Level III Site Plan Application
Seaport Lofts: Submittal No. 4

SUMMARY OF RESPONSES TO NELL DONALDSON EMAIL DATED SEPTEMBER 10, 2013:

SUMMARY OF RESPONSES TO DAVID MARGOLIS - PINEO EMAIL RECEIVED SEPTEMBER 13, 2013
(18 COMMENTS IN MEMO DATED AUGUST 13, 2013):

**SHEET 4 OF 14**

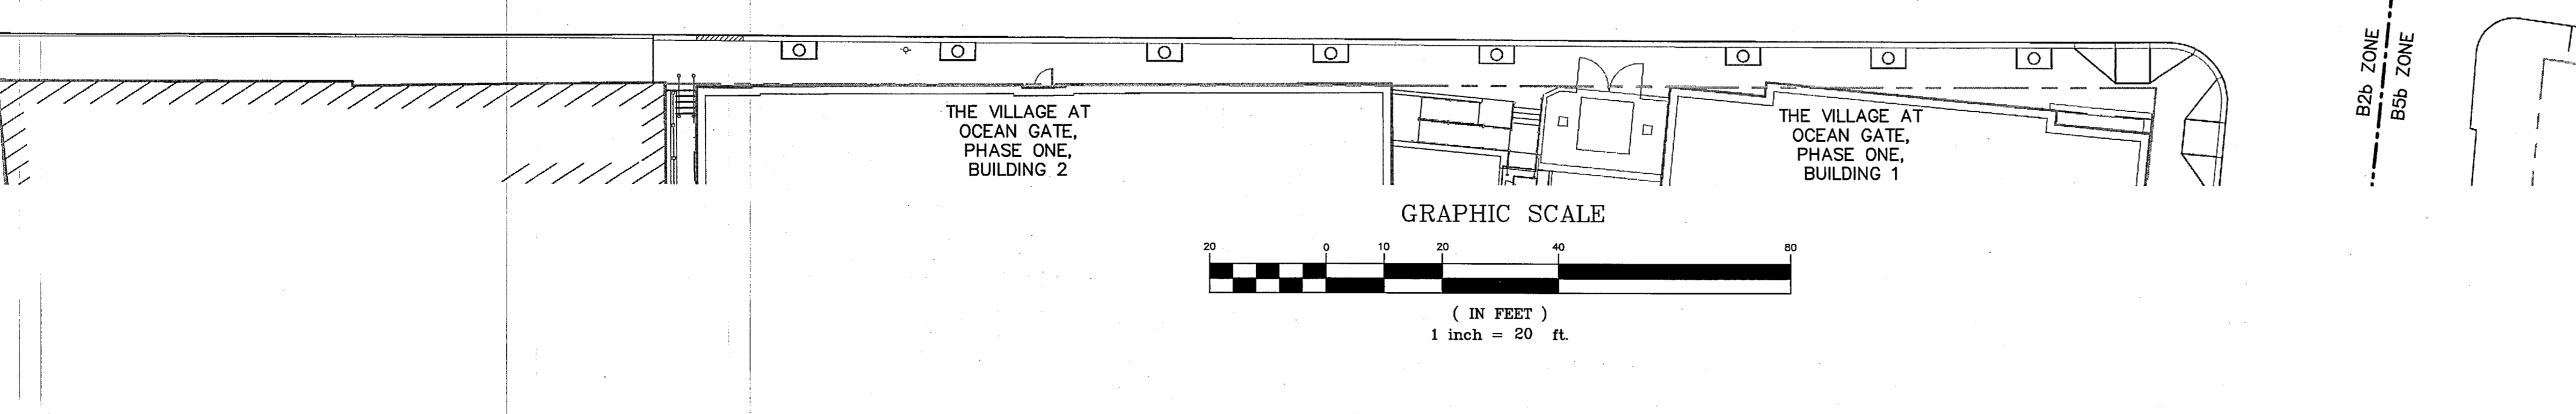
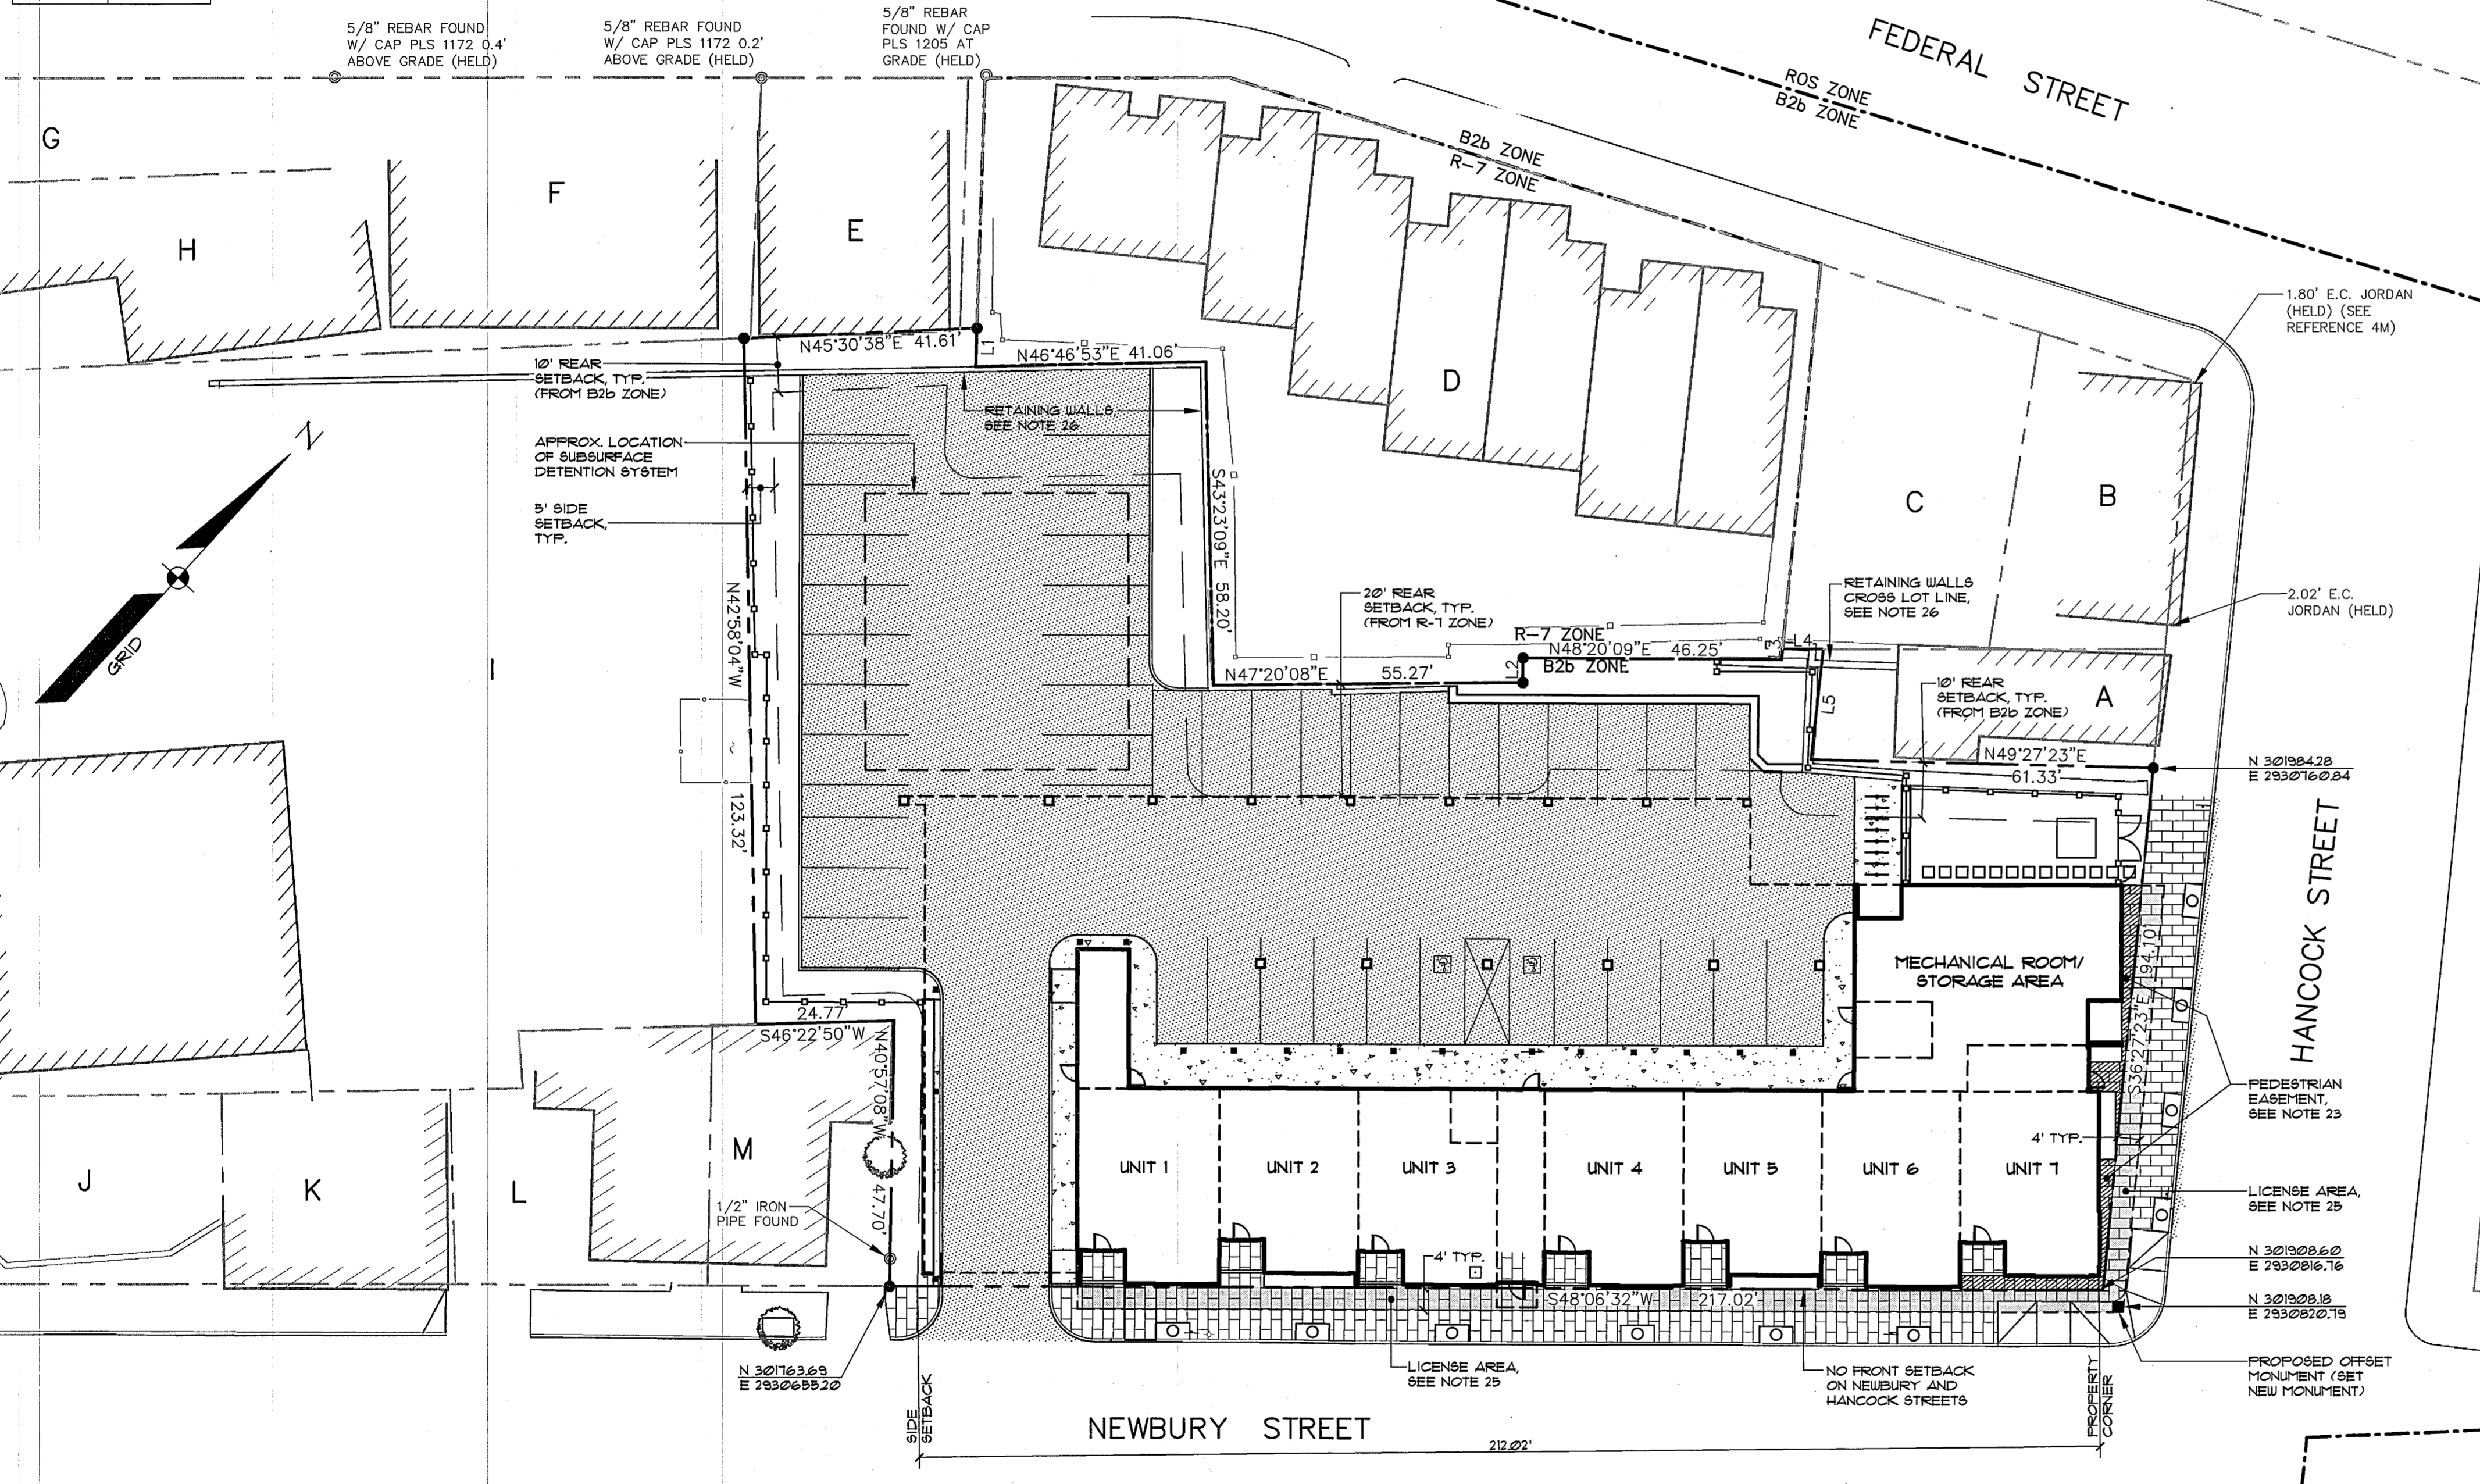
- State plane coordinates have been provided on the Recording Plat at the four locations requested.
- Property corners to be set have been added to the Recording Plat. Note that some corners occur on retaining walls and cannot be set, however, these walls serve as property monuments per the deed.
- The extent of the City License area has been added to the Recording Plat. See General Note 25.

- #14 The offset monument is shown on the Recording Plat as requested.
- #15 State Plane Coordinates are shown on the Recording Plat as requested.
- #16 Property corners to be set are shown on the Recording Plat as requested. Not all corners can be set as these occur at retaining walls; these walls act as property monumentation per the deed.
- #17 The initial survey plan was revised due to a conveyance from the record owner, which was not known to the applicant at that time, and has been corrected.
- #18 The retaining walls are on the property of the applicant, who will be responsible for maintaining them.

**SHEET 5 OF 14**

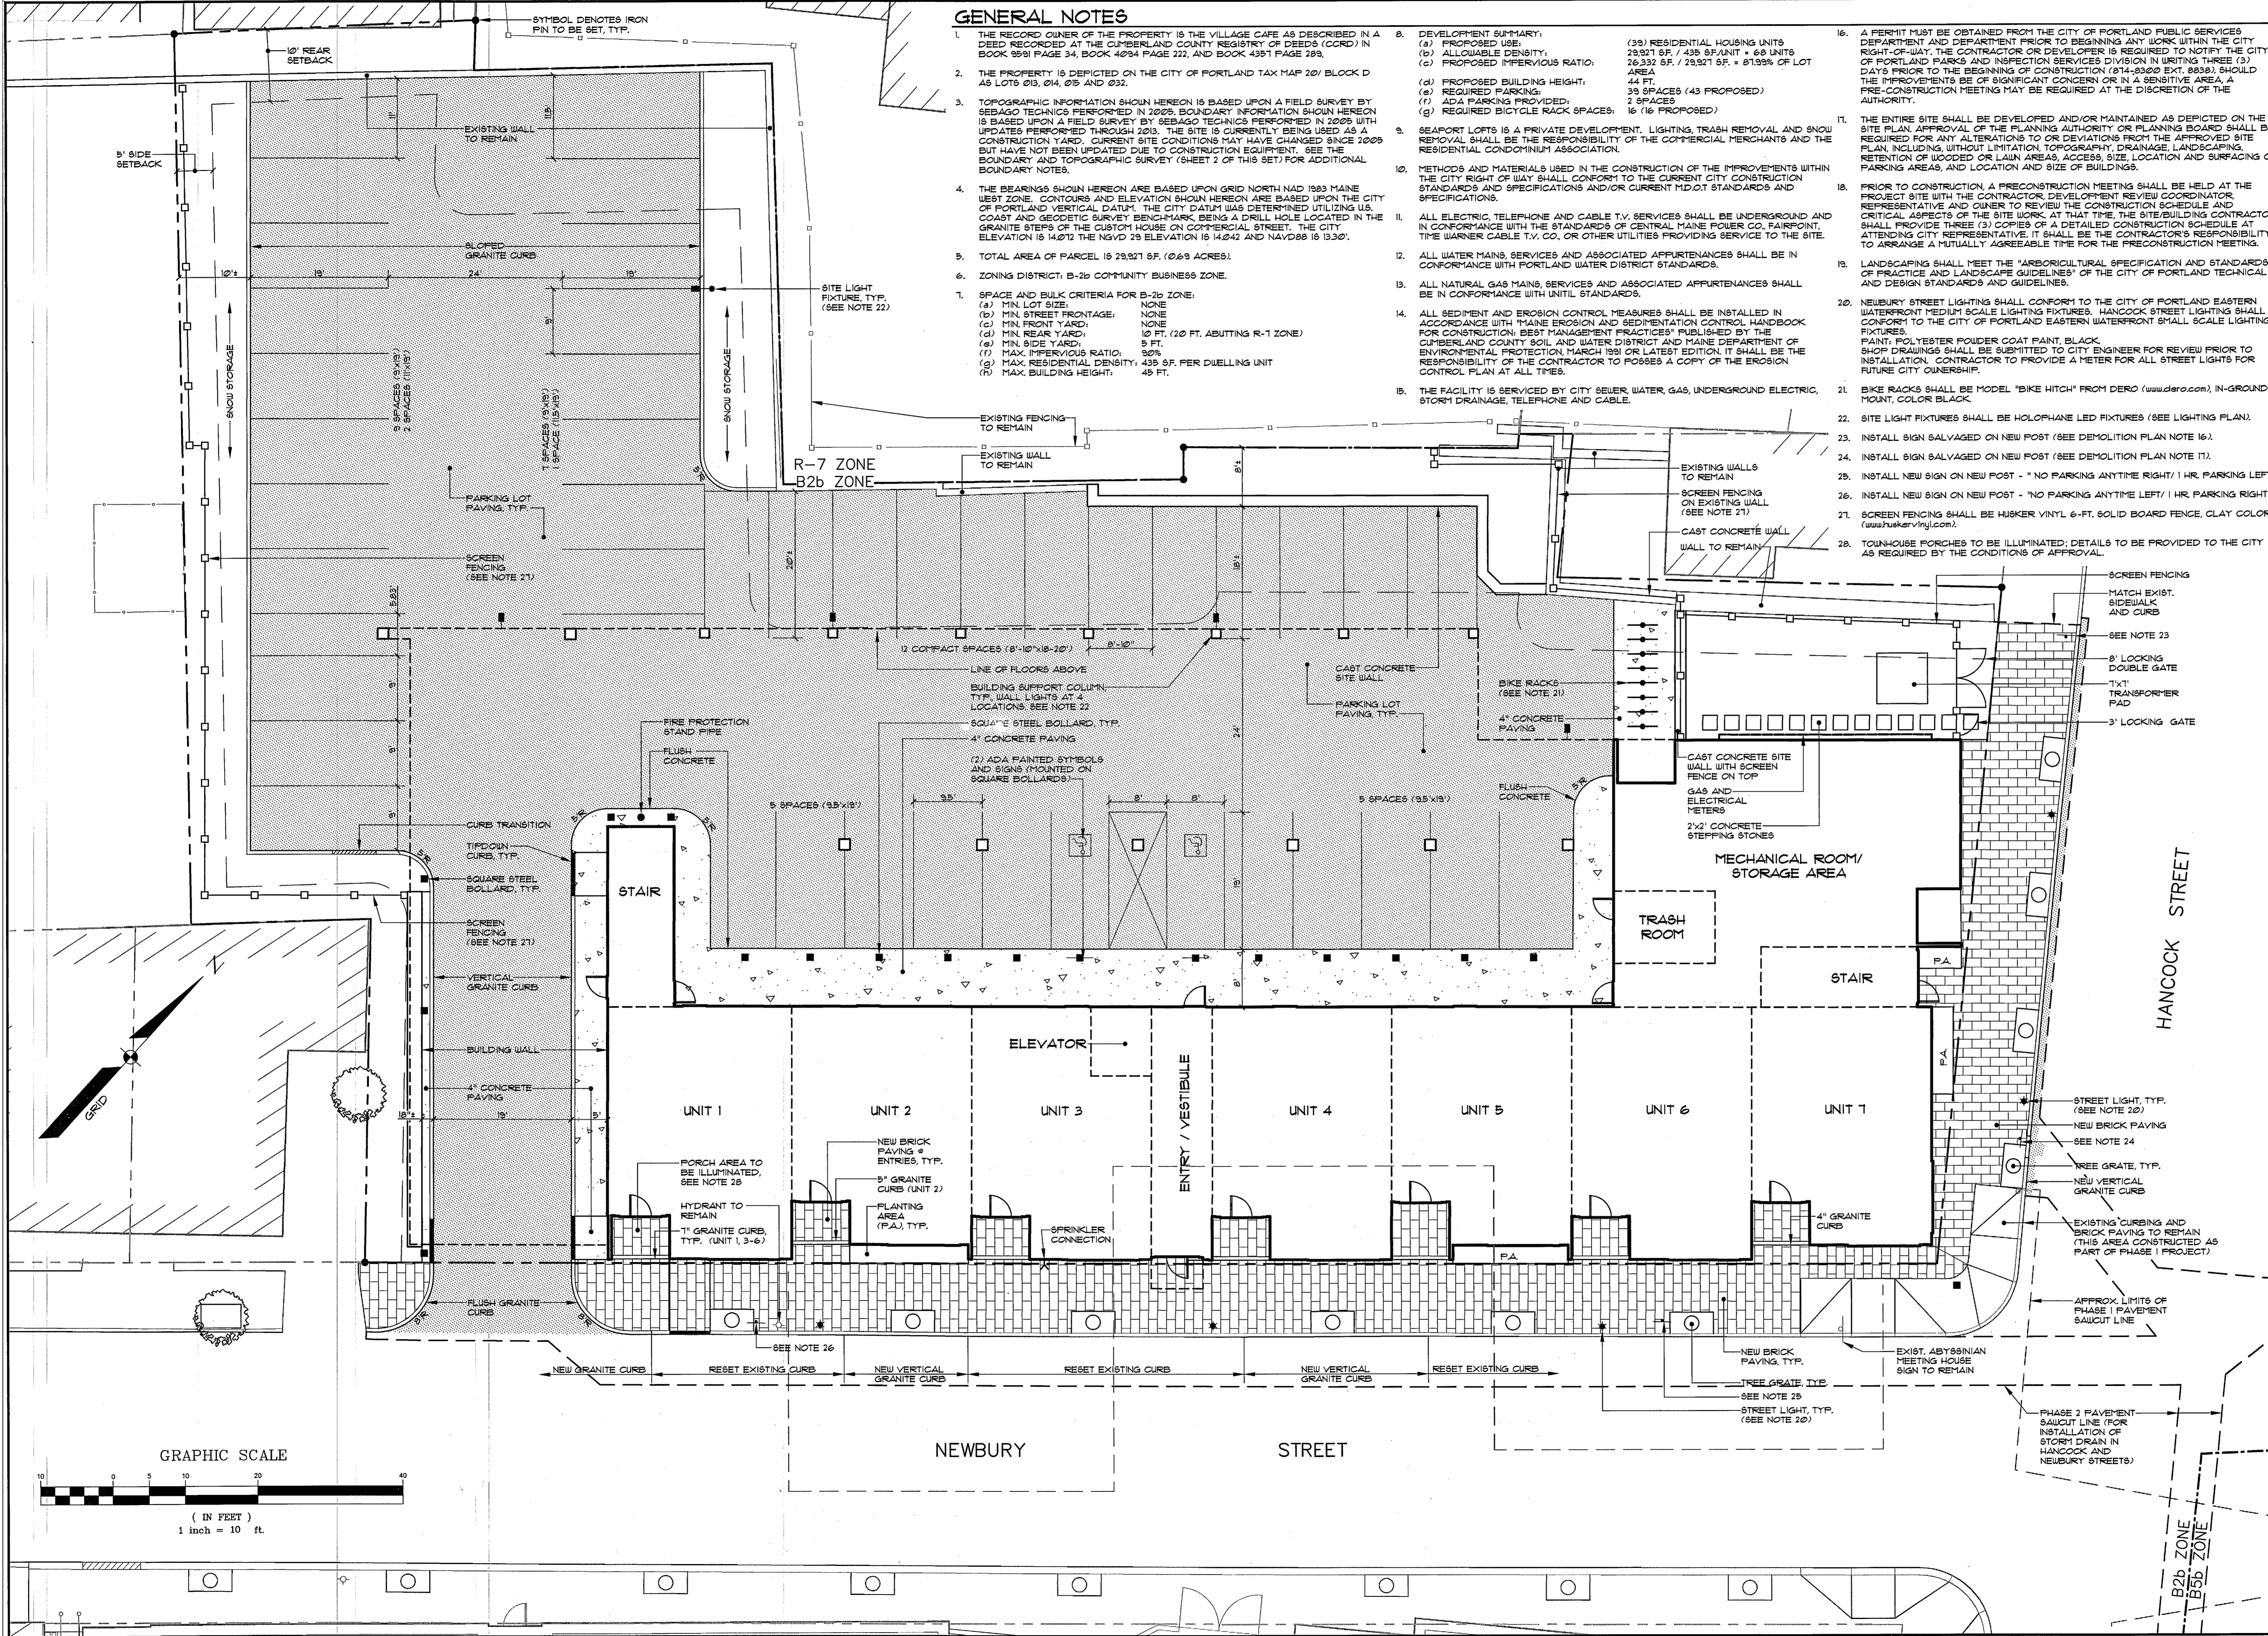
3. Regarding the dumpster – the owner has decided to instead provide a trash room near the mechanical room (Revised First Floor Plan enclosed). Trash will be stored in bins and collected by a contracted waste hauler. As a result, the project now includes 43 parking spaces. On the Site Plan, we have shifted two parking spaces in that area to eliminate conflicts with building column locations.

- The sprinkler connection location has been moved away from the entry vestibule as requested, see Site Plan.
- The address of the parcel is 113 Newbury Street. At this time we are uncertain about postal addresses, however, we can provide this to the Fire Department when determined.
- The standpipe connection has been relocated close to the stair area, as suggested, see Grading Plan.
